**Applied Engineering and Surveying, Inc.**

December 30, 2003

RE: RESPONSES TO YOUR COMMENTS DATED SEPTEMBER 18, 2003  
FOR THE E.L. PORVENIR SUBDIVISION, (ARNO SUBDIVISION )  
GRADING AND DRAINAGE PLAN (J-19/D37), ENGINEER'S STAMP  
DATED AUGUST 11, 2003

E.L. Porvenir Subd

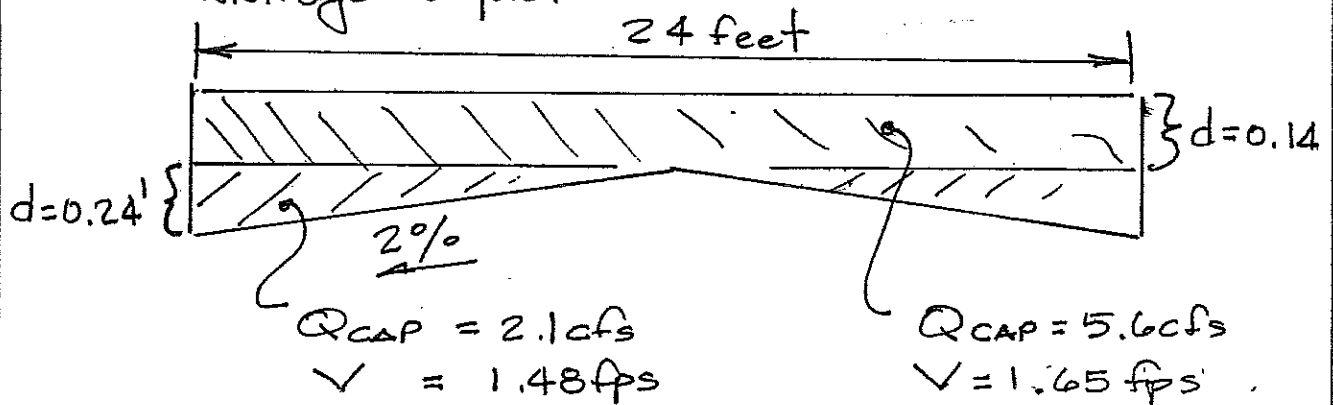
1. Please see attached calculations, the plan is to move the sidewalk behind the mountable curb for approximately 95 feet east of Arno Street in-order to maintain the velocity head within a hardscape structure.
2. As per our discussions the details for the railroad tie retaining wall show concrete placed in the hole for the railroad ties, also the requirement of depth of burial equal to height should sustain the wall for quite some time. The sediment pond and swales will be maintained by the private property owners, such maintenance language will also be included in the plat.
3. A bench mark is now included on the plan.
